Doncaster Avenue Student Accommodation-Mod-1 (SSD-9649-Mod-1)
Request for additional information

I refer to Assessment for the Doncaster Avenue Student Accommodation-Mod-1 (SSD-9649-Mod-1).

Picture 2 Proposed OSD Location

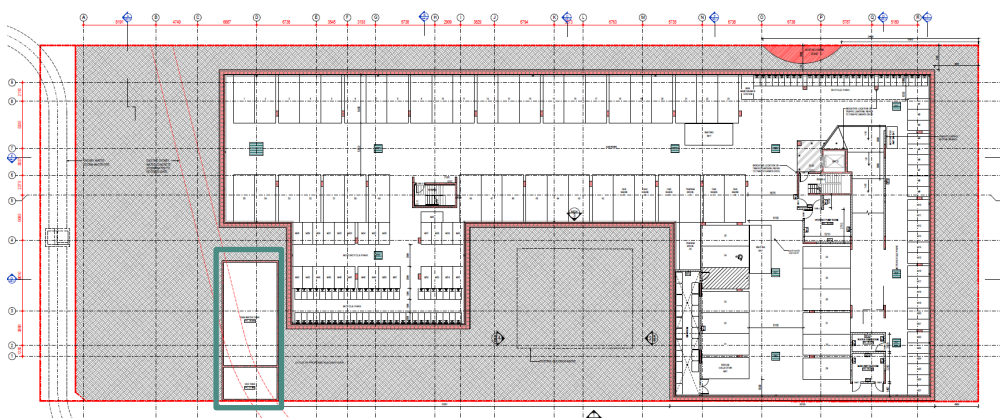
The Department notes that the proposed location of the OSD tank within the approved front landscape setback, may impact the approved landscaping and communal courtyard design.

**Figure 5 | Extract of Proposed Landscaping – lawn area raised to generally align with surrounding levels (Base source: Applicant's RtS)**

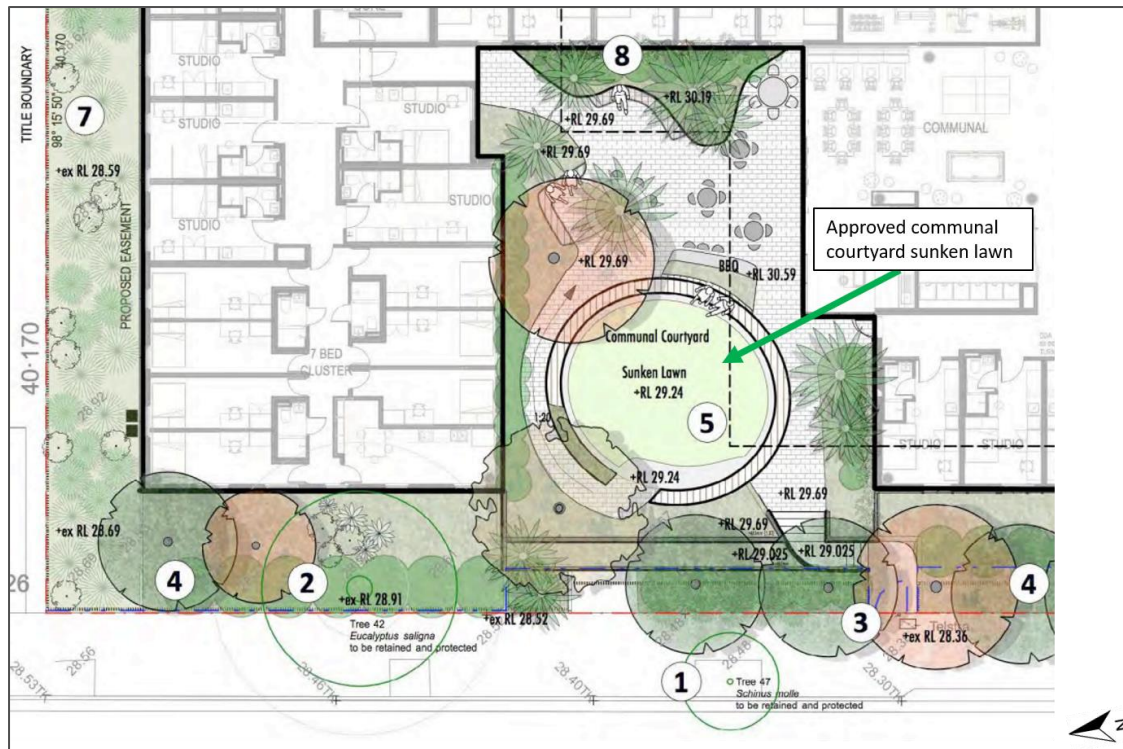
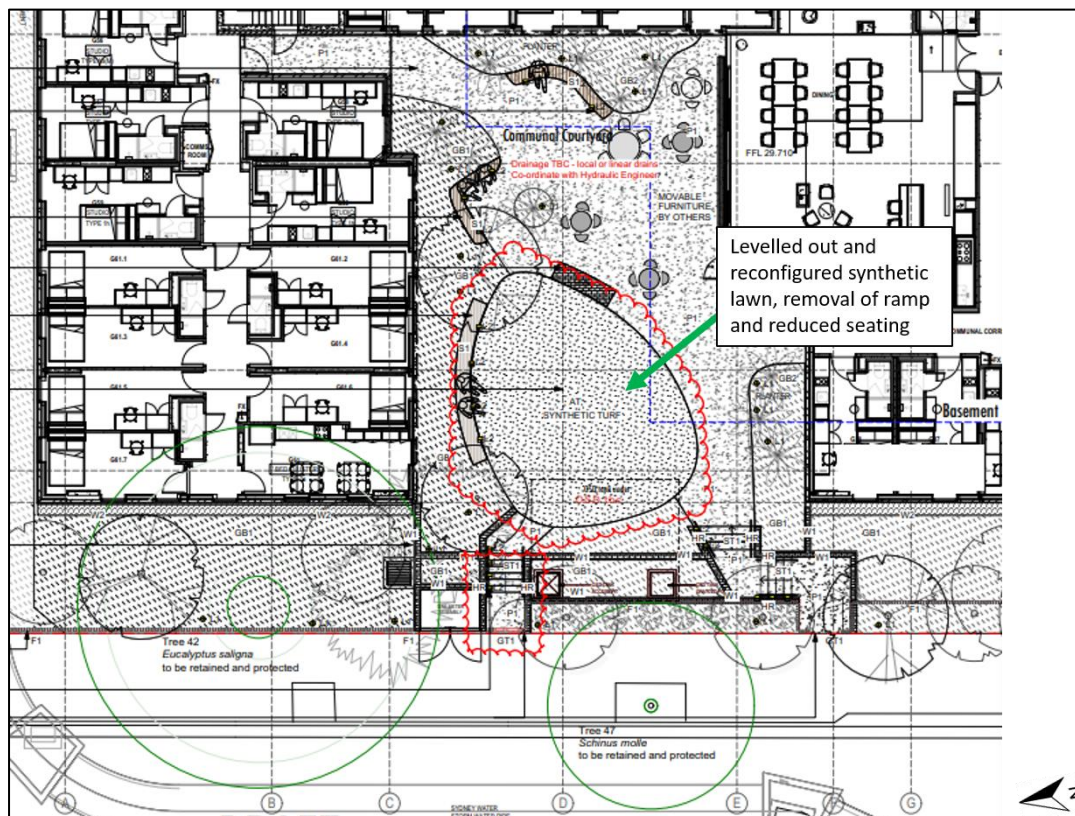
The Department, therefore, requests that you provide amended landscape plans which demonstrate how the landscaping is compatible with the revised OSD tank location and maintains a high-quality landscape design and streetscape setting for the building.
